MONA OFFSHORE WIND PROJECT

Appendix to ExQ1 Q1.5.1 Scallop Mitigation Zone

Application Reference: EN010137

Document Reference: S_D3_25.4

Figure 1.3: Indicative location of Scallop Mitigation Zone.

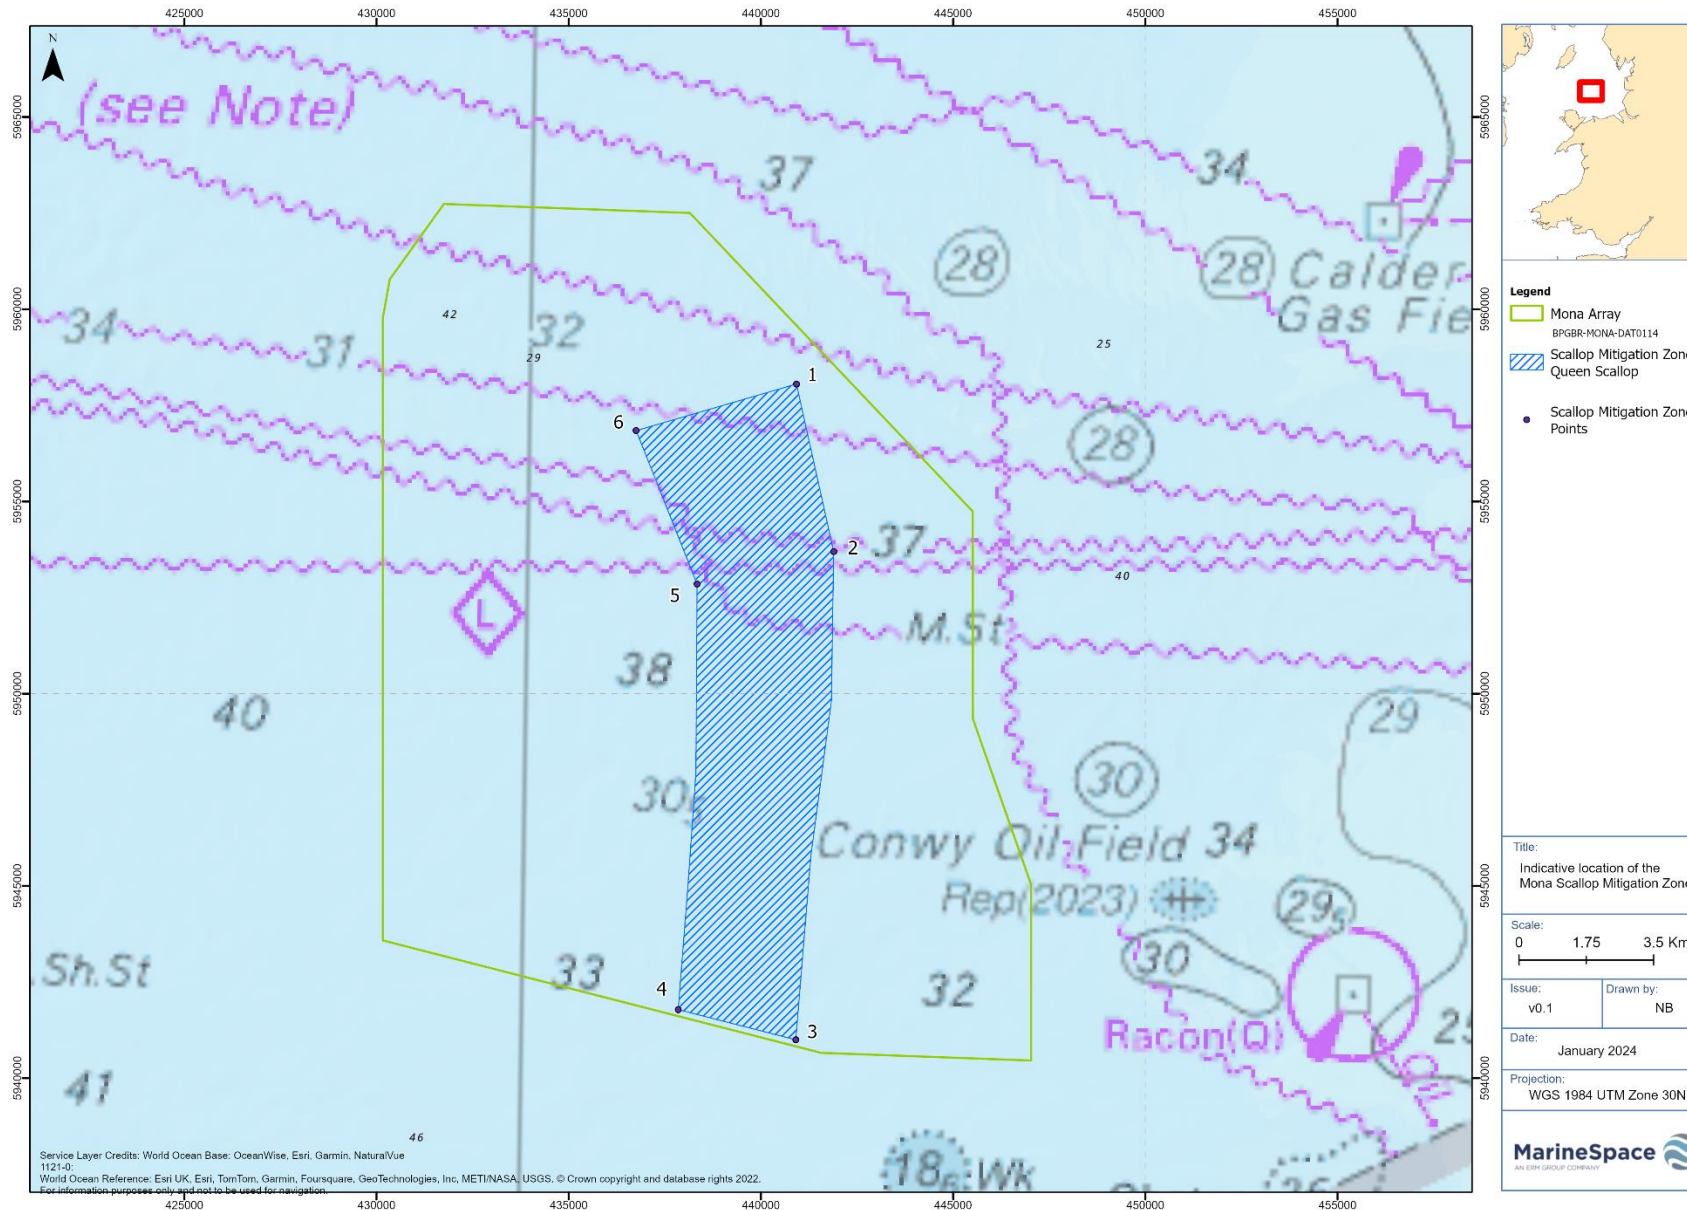
The Applicant's response to REP1-075.10 [REP2-078] states that it will commit to maintaining a Scallop Mitigation Zone (SMZ) of 57 km² by including this commitment within an update to Table 1.2 of the Outline FLCP [APP-199] at Deadline 3. As the size is much smaller in area than what the Scottish Fishermen's Federation, the Scottish Whitefish Producers Association Ltd and the West Coast Sea Products expected can the Applicant:

- i) summarise the steps it took to evaluate smaller and larger sizes and how a 57 km² SMZ area size was selected;
- ii) clarify if rock protection footprint for cables would have an impact on the size of the 57 km² SMZ; and
- iii) explain what the effects would be on the Proposed Development if it increased the SMZ by 20- 25% in area size.

1.2.1.1 The Applicant highlights that the Outline Fisheries Liaison and Co-existence Plan (J13 F02) has been updated for Deadline 3 to secure a minimum area of 57 km² for the SMZ.

- 1.2.1.3 Based on this feedback, the Mona Offshore Wind Project designed the SMZ to cover 100% of the 'Very Important' ground (Figure 2.1), which covers 37% of the wider queen scallop grounds. The term 'core queen scallop ground' was adopted by the Applicant to describe the area covered by the SMZ and to and recognise that it covered the 'Very Important' (or 'core') ground rather than all of the grounds.

1.2.2.2 Where cables are required to be routed through the SMZ and a portion of those cables require cable protection there would be a reduction in the total area of the SMZ. However, due to the small footprint of cable protection, it is not expected to affect the purpose or effectiveness of the SMZ for providing continued access the core queen scallop ground. This is because:

- A single cable running from north to south through the centre of the SMZ would be approximately 16 km in length. The maximum width of cable protection would be 10 m (0.01 km) (as set out in Table 3.9, 3.22 and 3.25 of APP-050). Assuming the entire cable needed to be protected (an unrealistic scenario, explained further below), the footprint of the cable protection would equate to 16 km x 0.01 km = 0.16 km² and a 0.3% reduction in the total area of the SMZ.

- Cables crossing the SMZ in a worst-case east-west orientation in the north, south and middle of the SMZ would have lengths of approximately 4.3, 3.2 and 3.5 km respectively, with an overall length of 11 km and footprint of 0.11 km² and a 0.3% reduction in the total area of the SMZ (again, assuming an unrealistic requirement for 100% protection of cables). Moreover, doubling the number of cables crossing the SMZ in an east-west orientation would still likely result in a less than 1% reduction in the SMZ.
